Our Ref: R/105/18/PL
Your Ref:

Town & Country Planning Act 1990 (as amended)
Town and Country Planning (Development Management Procedure) (England) Order 2015
Application for Planning Permission

Development	Change of use of integral garage to form treatment/waiting room, 2 No. dormers to first floor front extension, replacement of rear dormer with 1 No. velux window, balcony to rear extension, change of side window to window & door & 1 No. additional velux to ensuite (amendment to R/45/17/PL).
Location	Sandon The Coppice Rustington

EXISTING GROUND FLOOR PLAN 1:50

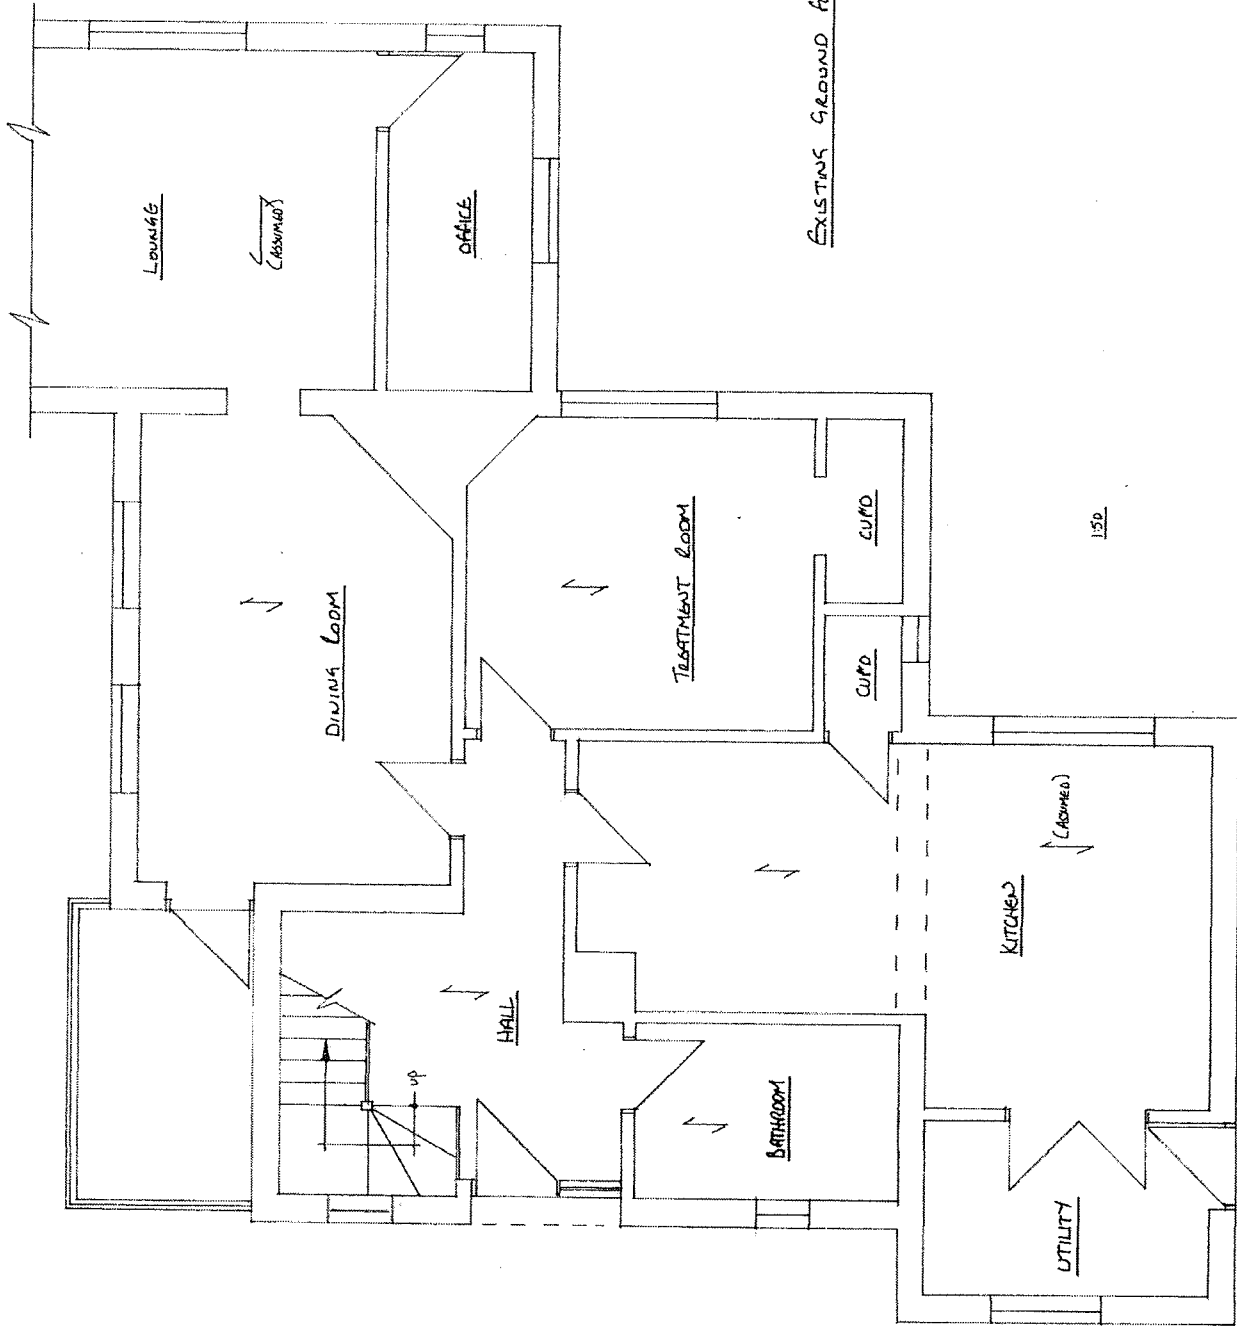
Please provide existing floor plans.

PROPOSED GROUND FLOOR PLAN

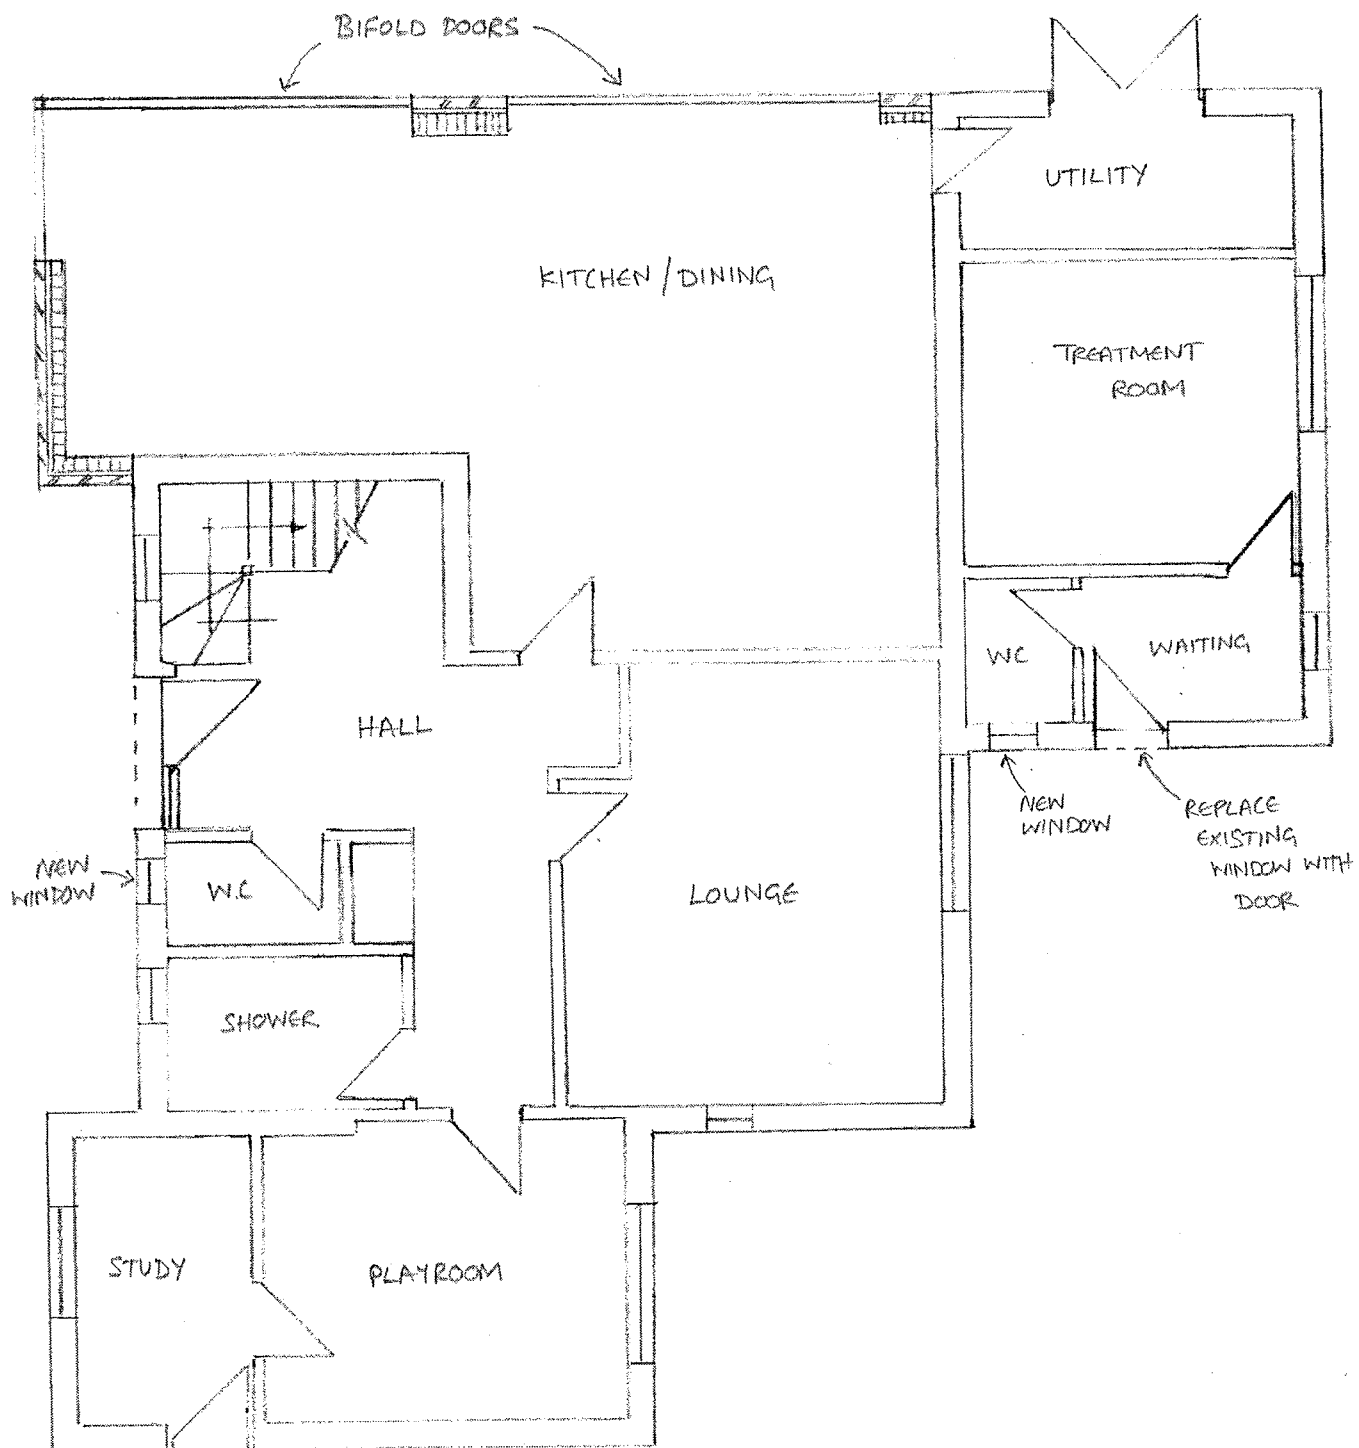
The proposed floor plans and proposed elevations do not scale correctly. Please amend accordingly.

PROPOSED FIRST FLOOR PLAN

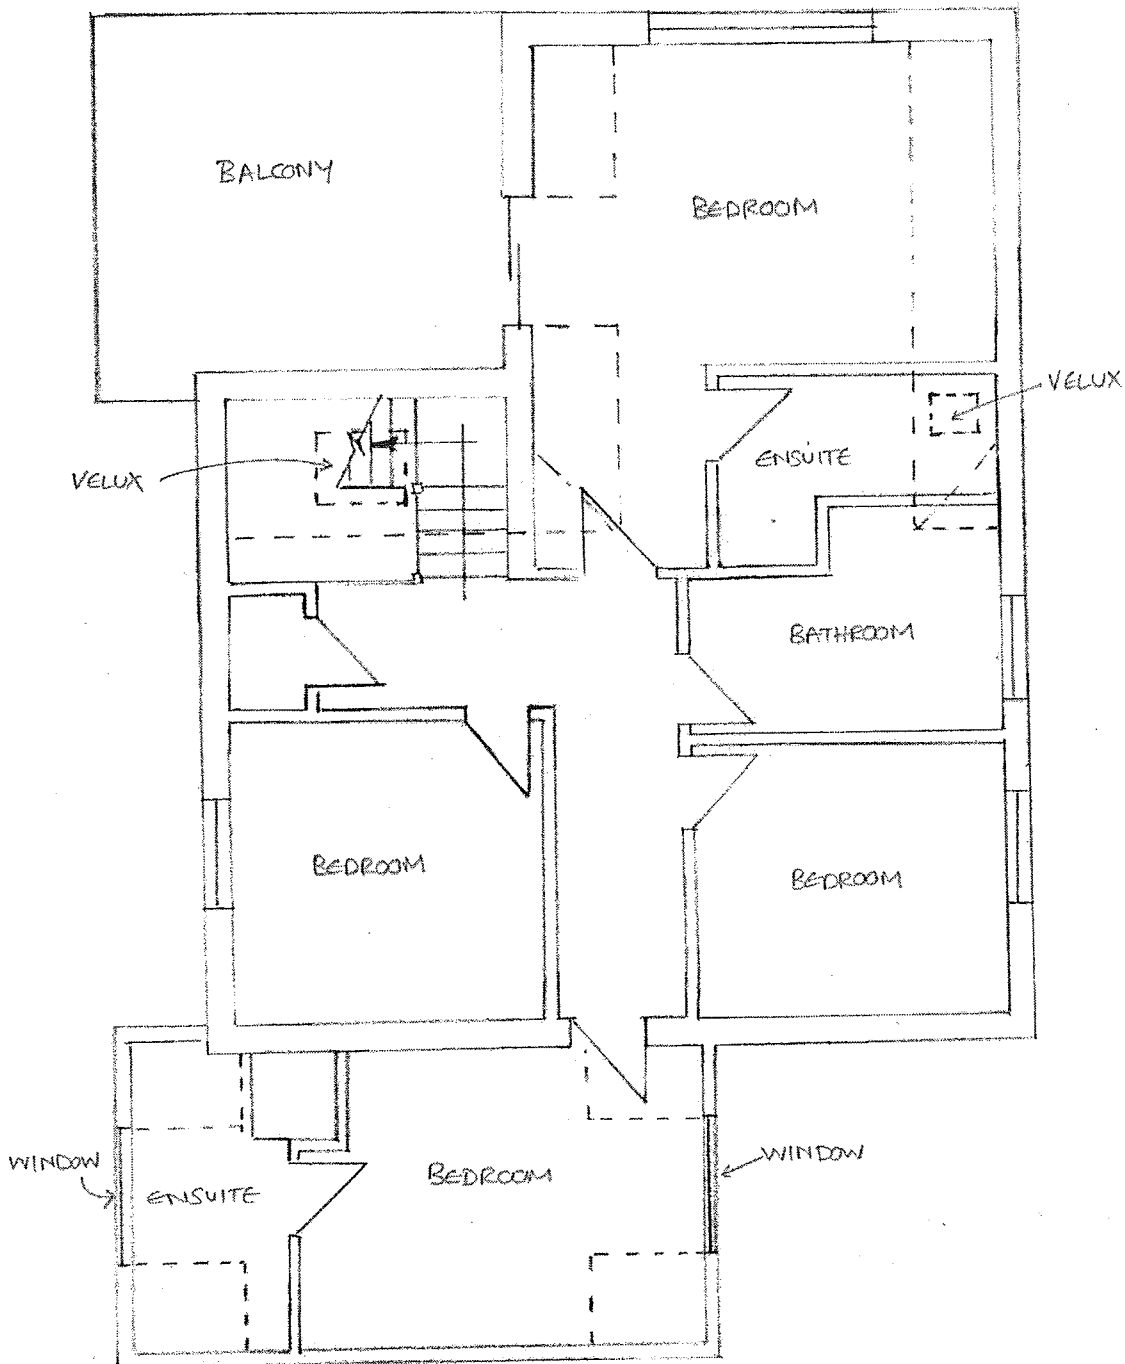
The proposed first floor plan and side elevation do not accord. Please amend accordingly.

1:500

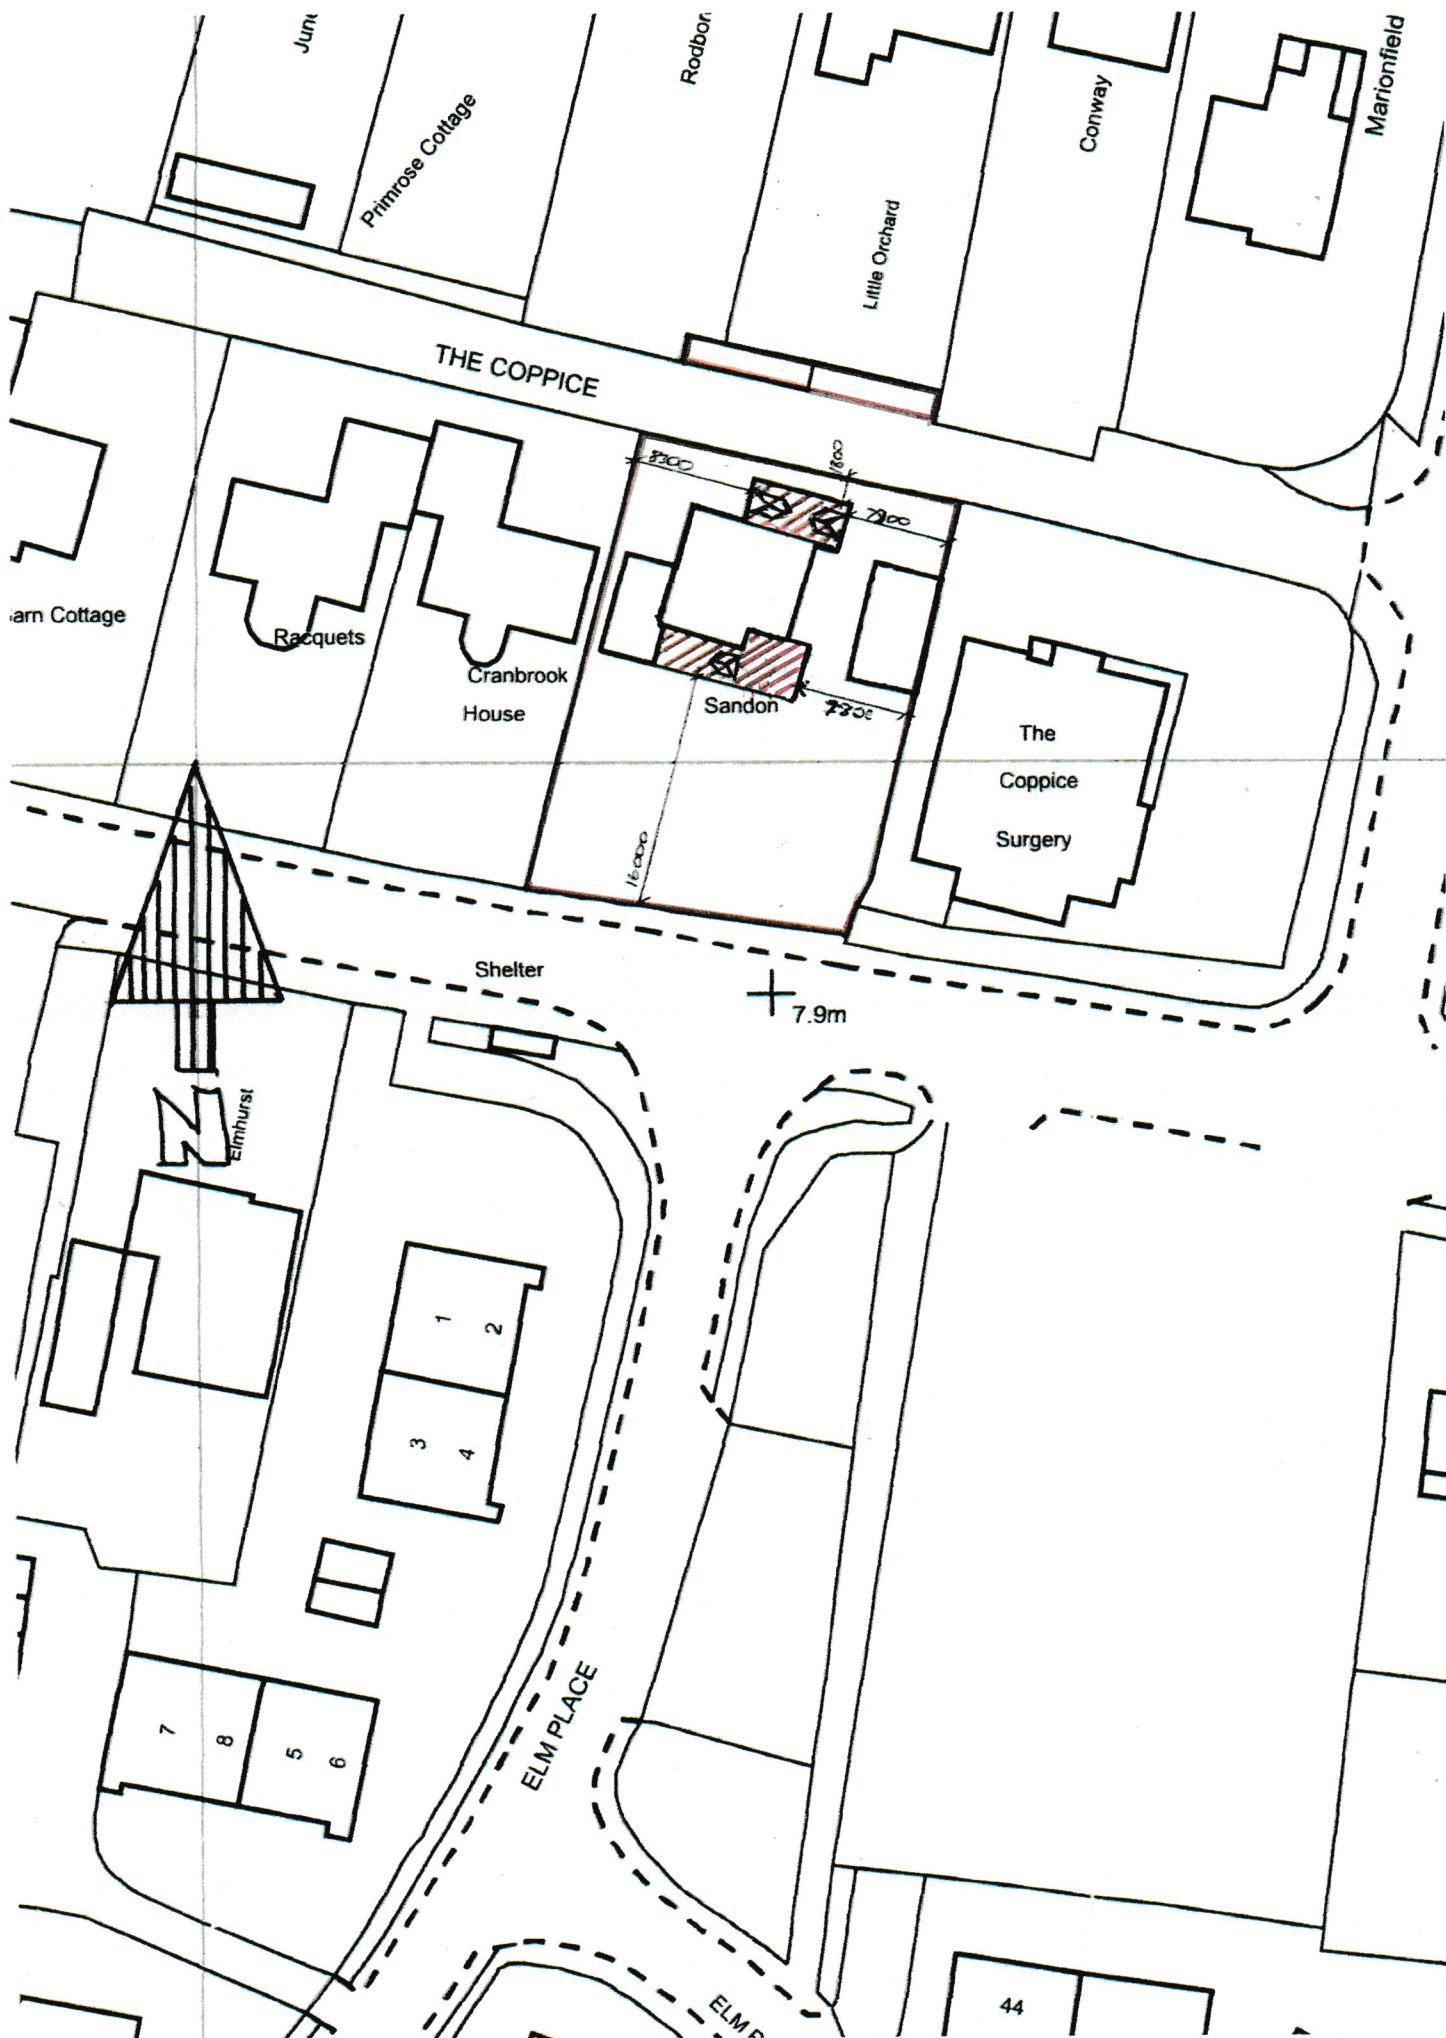
Please submit 1 electronic or 3 paper copies of a block/site plan at a scale of 1:500 or 1:200. Further details of what must be included on the plan can be found in the National Validation Requirements. Please only highlight the proposals to do with this application.
